The Member Secretary,
Chennai Metropolitan
Development Authority,
No.8, Gandhi Irwin Road,
CHENNAI -600 008

Letter No.B 1/8603/2000

Dated: 08.06.2000.

Sub: CMDA - Area Plans Unit - Planning Permission -
Construction of Ground Floor + 2 Floor resi-
dential building with 6 dwelling units at
S.No.116/2B1A of Valasaravakkam village -
Development Charges and Other Charges to be
remitted - Regarding.

DETAIL OF SEPTIC TANK (SCALE 1:50)
 UP FLOW FILTER

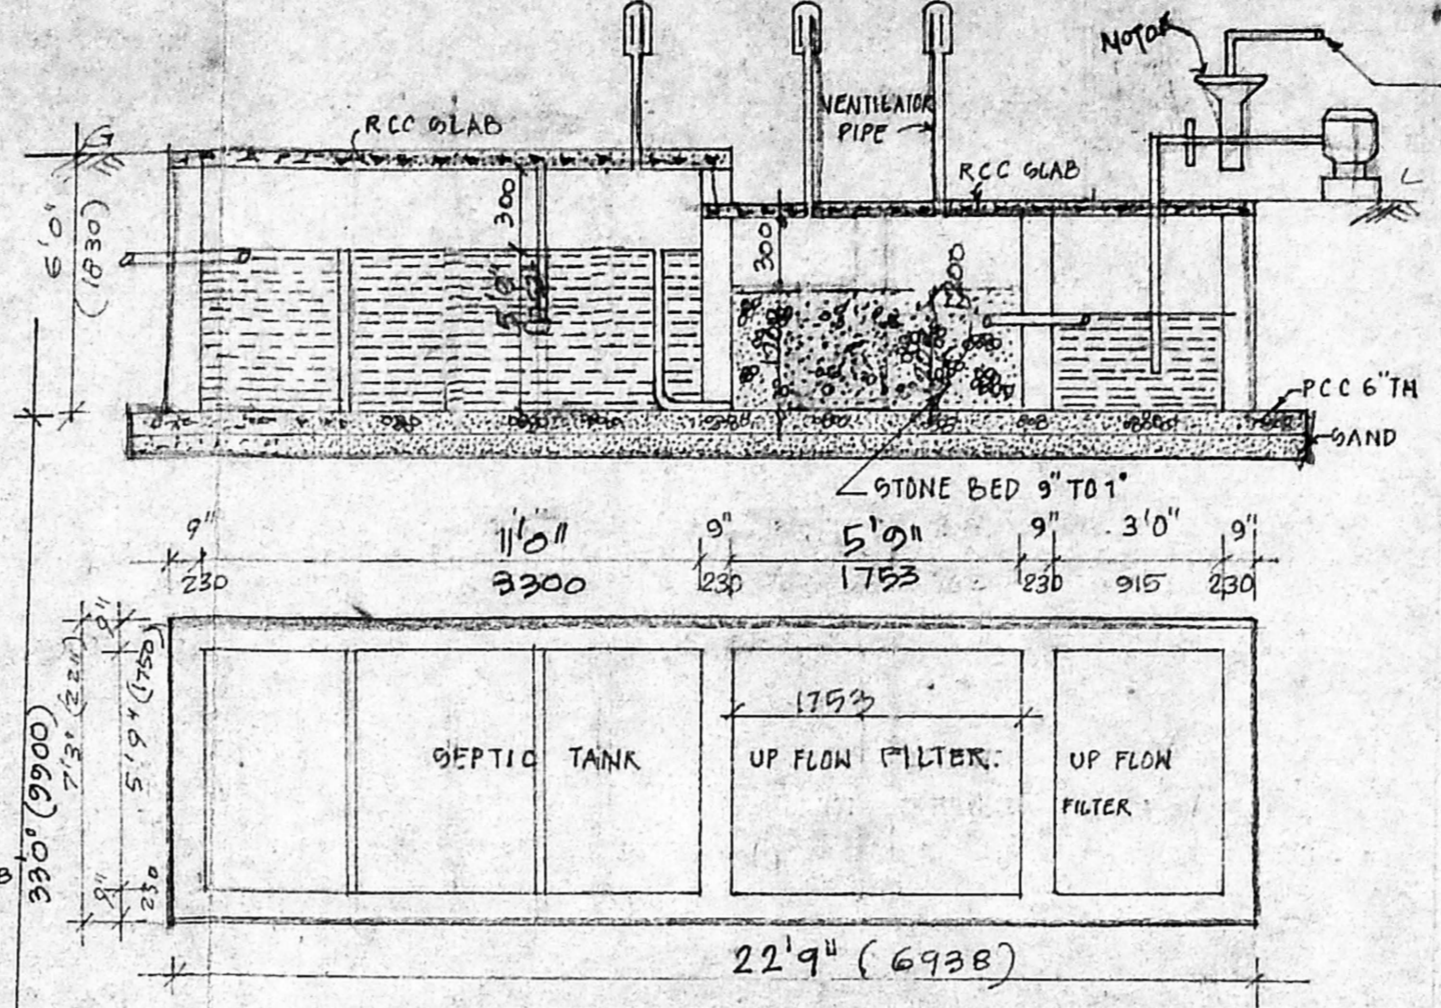
- a) Both the dimensions as per document and as on site have to be shown clearly distinguishing the differences by *hatching* taking and leaving minimum required set back from the least line.
- b) Revised Plan satisfying the Side Set Back requirements (Required is 3.50M, provided is 3.43M). This is due to the variation of dimensions in the overall building in the Ground Floor Plan.
- c) S.No. as per patta to be mentioned in the title of the drawing.
- d) S.No. mentioned in the schedule of General Power of Attorney deed is not correct.
- e) The breakup dimensions of Ground Floor Plan do not tallying with the overall building dimension.
- f) Design calculation for the septic tank up flow filter has to be furnished.
- g) Revised site plan showing the parking arrangements.
